From: Laura Gibbons
Sent: 26 April 2019 11:28
To: Planning.Responses
Cc: Simon Davis
Subject: RE: Planning Consultation on: AL/33/19/RES

Engineers Comments Regarding Surface Water Drainage

APPLICATION NO: AL/33/19/RES

Site Address: Barnside Hook Lane Aldingbourne PO20 3TE

DWG | Proposed Site Plan

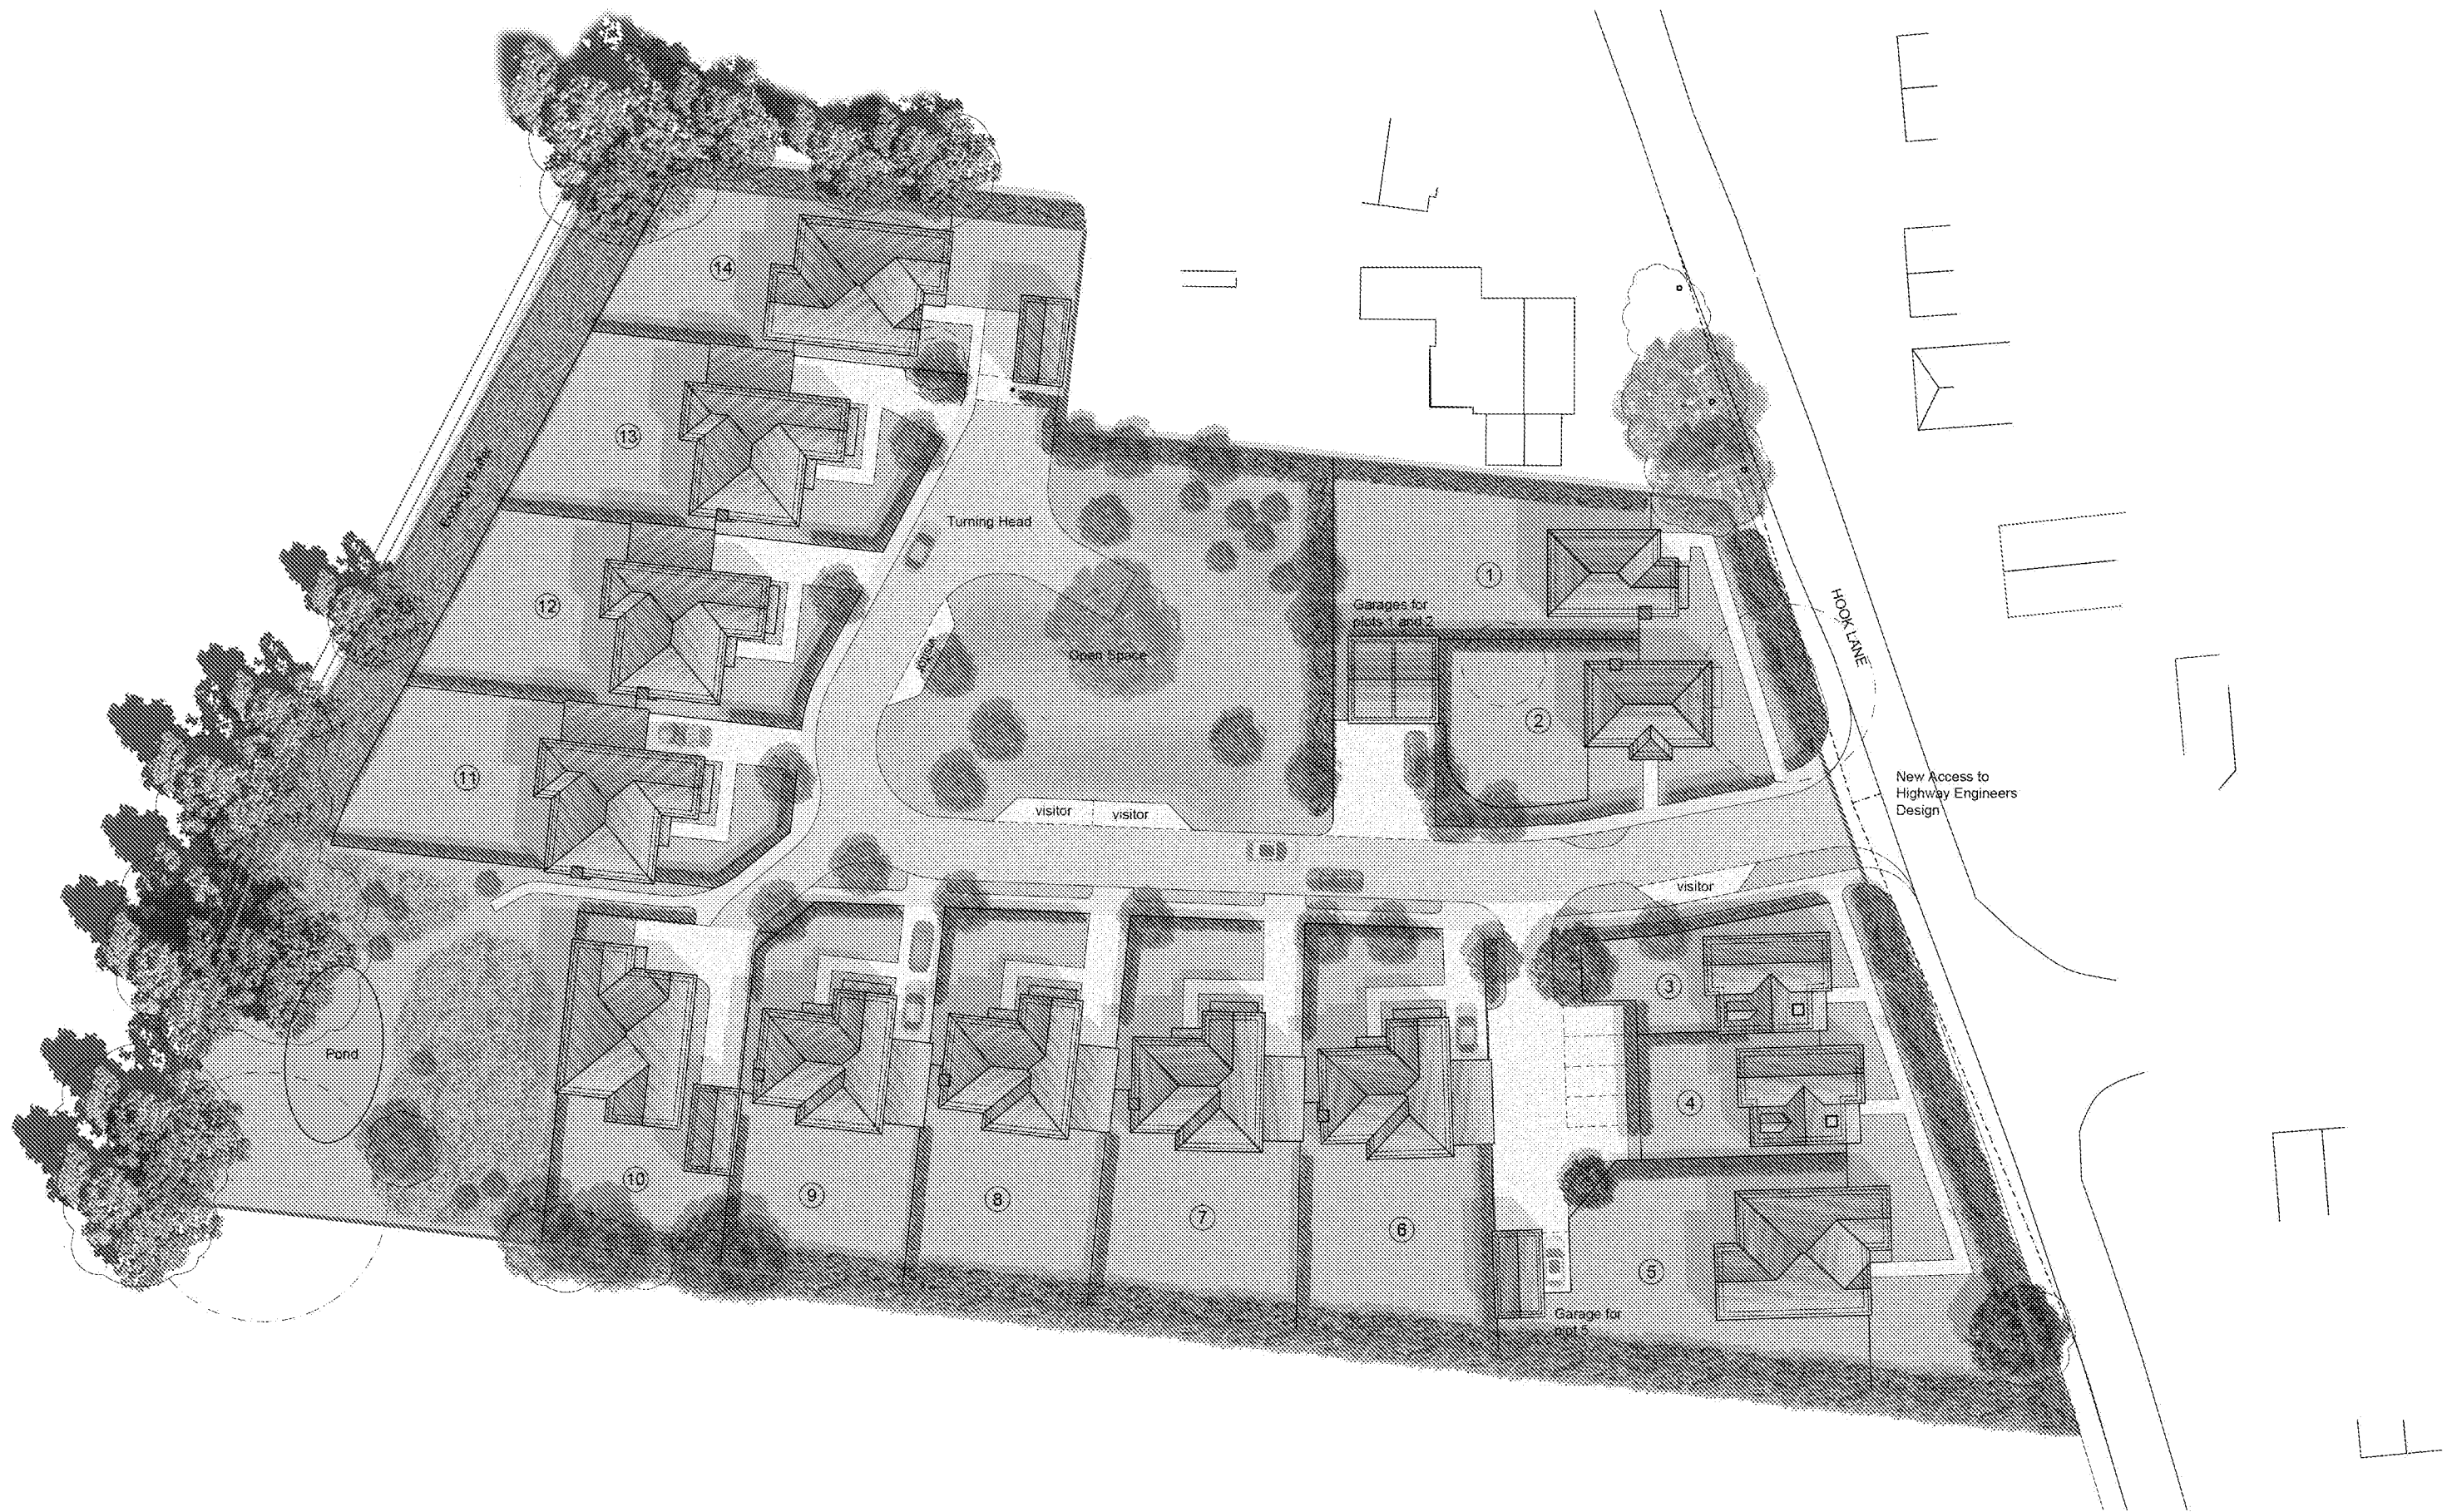
2. The existing and proposed interconnectivity between the pond and watercourse is unclear. Our mapping shows that there is currently a connection from the pond to the ditch to the south, is this to be infilled? Furthermore, invert levels of the watercourse need to be provided to demonstrate that discharge to watercourse via gravity is achievable. Therefore, the overall methodology for surface water drainage cannot be assessed.
